From: Peter Cleveland
Sent: 21 September 2011 08:40
To: Planning.Responses
Subject: FW: EP/85/11/TC South Eastern Corner of Church and grounds St Mary's Church Station Road/Vicarage Lane East Preston BN16

From: Ian Brewster
Sent: 20 September 2011 17:33
To: Peter Cleveland
Subject: EP/85/11/TC South Eastern Corner of Church and grounds St Mary's Church Station Road/Vicarage Lane East Preston BN16

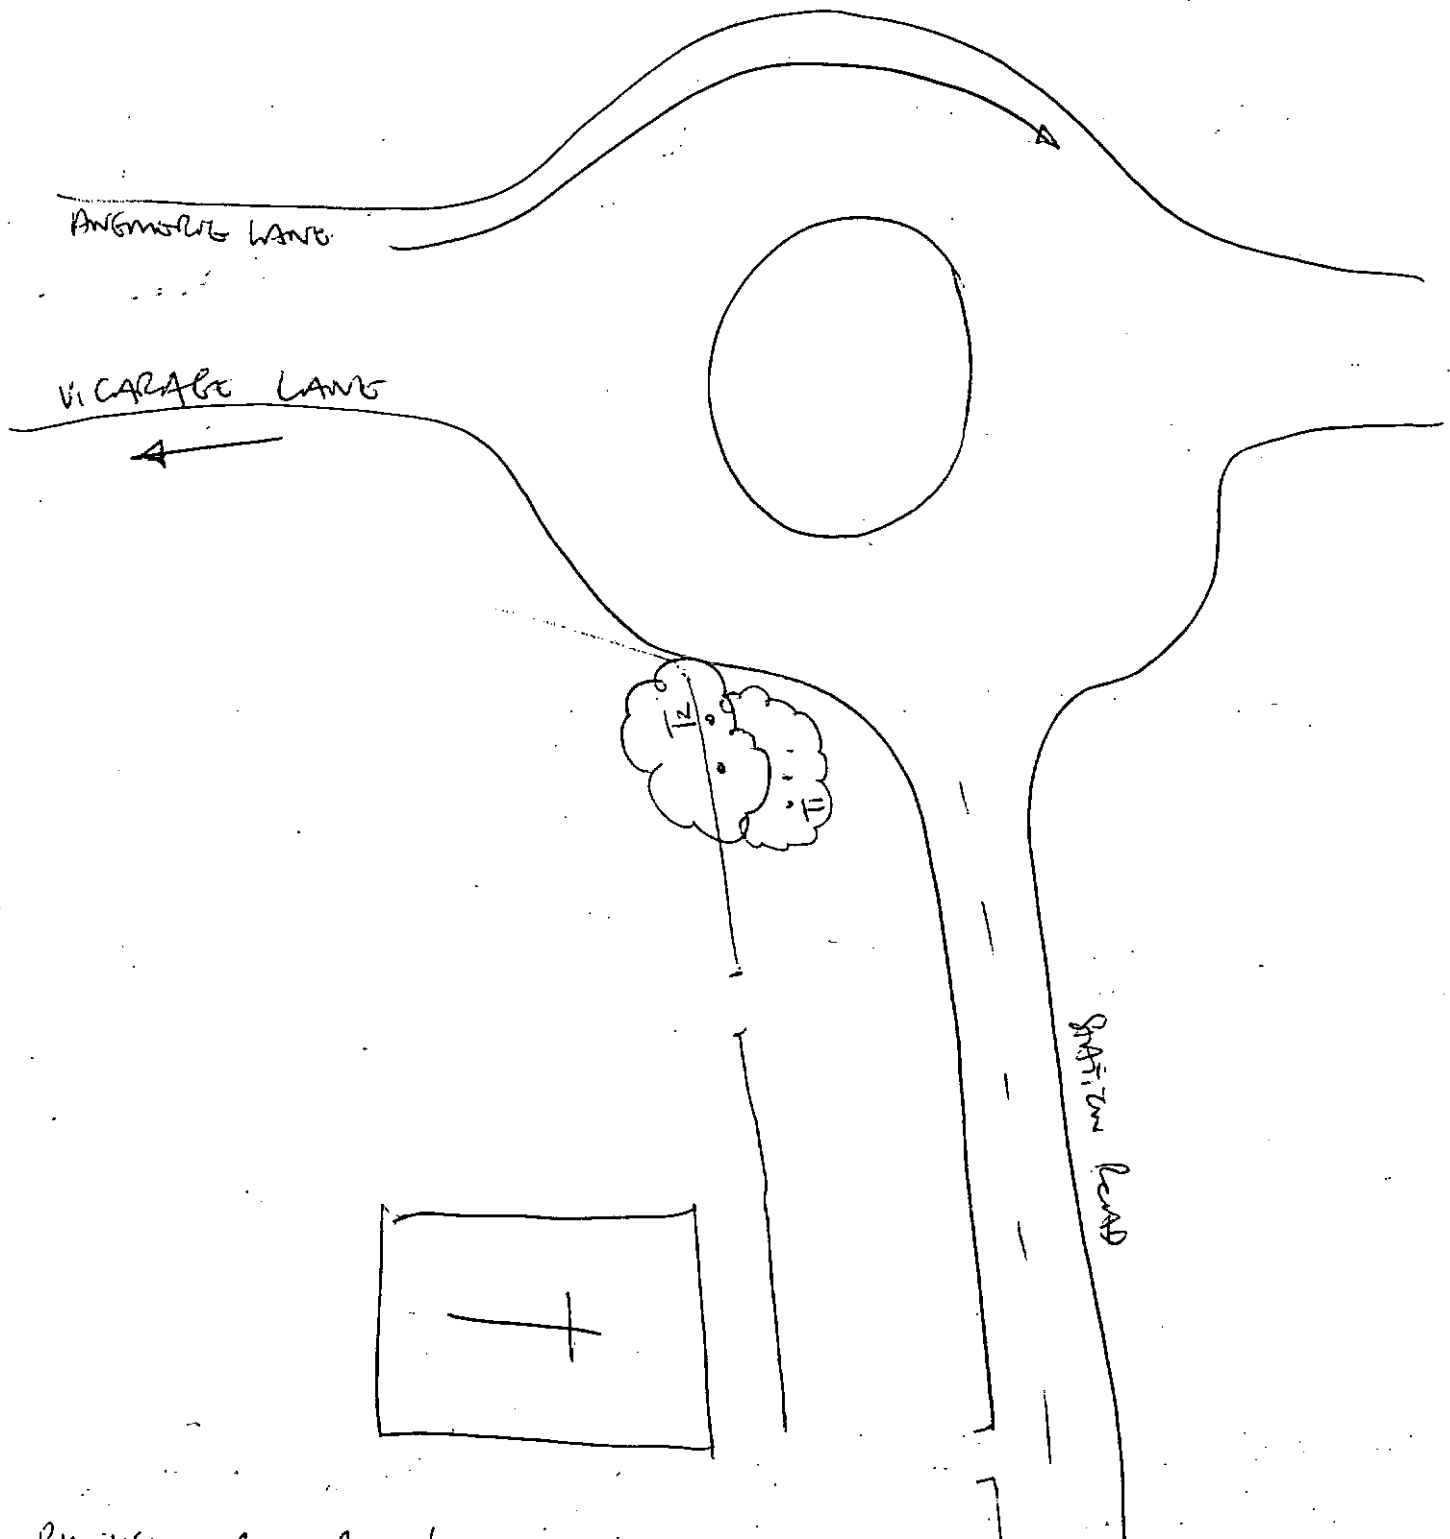
I have no objection to the reduction work though couldn't identify the Euonymus as it simply wasn't there!. However the Beech hedge has growth through the bay laurel and will need to be cut back to the originally intended hedge height as it is also beginning to obscure the highway sign.
